# Rezoning Transportation Analysis

Petition Number: 2022-151

General Location Identifier: 02711418

Date	Description
1-25-23	First Review (TM)

DRAWING NUMBER:
RZ-1

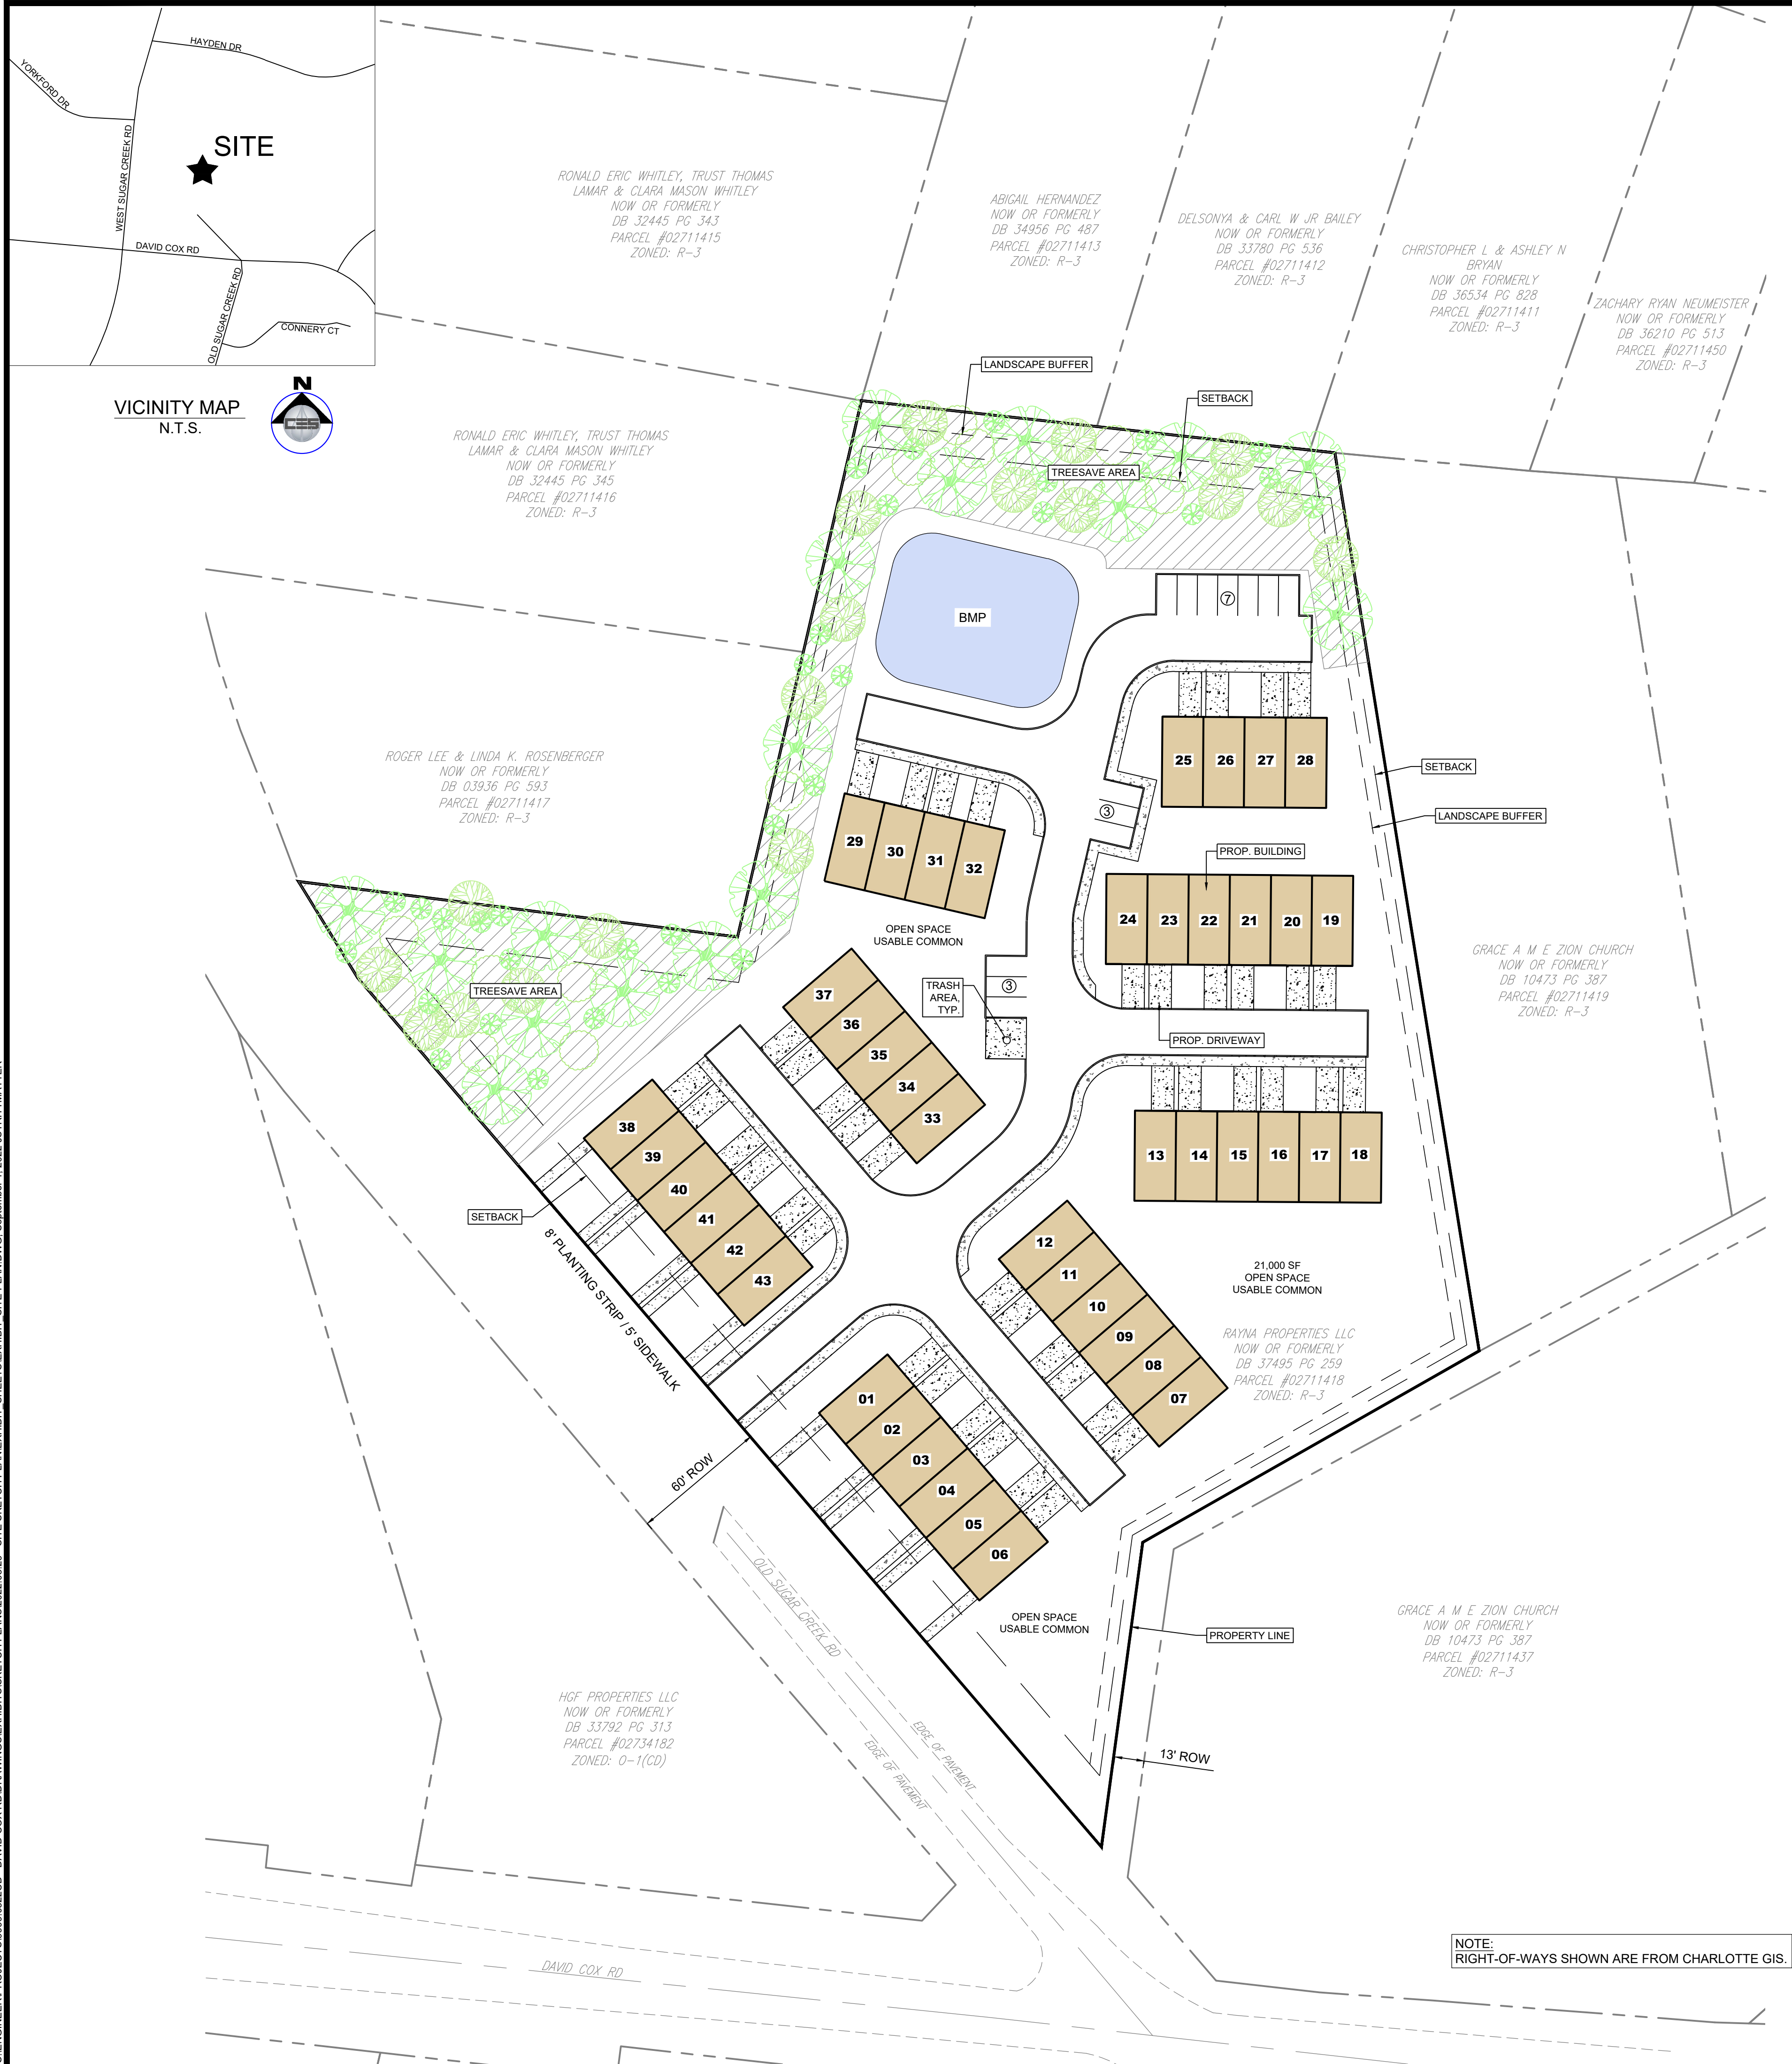
- a. **David Cox Road:** Location of future back of curb and gutter to be 19-feet from roadway centerline to accommodate the Charlotte Streets Map with a roadway typical section following that of 11-09 Minor Thoroughfare.

Label and dimension the curb and gutter from the centerline for each road on the site plan.

3. Revise site plan and conditional note(s) to commit to construct an 8-foot planting strip, and 6-foot sidewalk on newly constructed road per Chapter 19. The site plan shall label and dimension both items from the back of curb and gutter or edge of pavement.

6. Revise site plan and conditional note(s) to commit to constructing a roadway perpendicular to David Cox Road. This roadway will extend to/through and include infrastructure detailed in U-02. Roadway shall expand the existing alley to public roadway standards per CLDSM U-02. Site plan shall callout and dimension roadway infrastructure and associated right of way from roadway centerline. Add a

conditional note committing the construction of the road to CLDSM U-02 standard along with the related infrastructure.
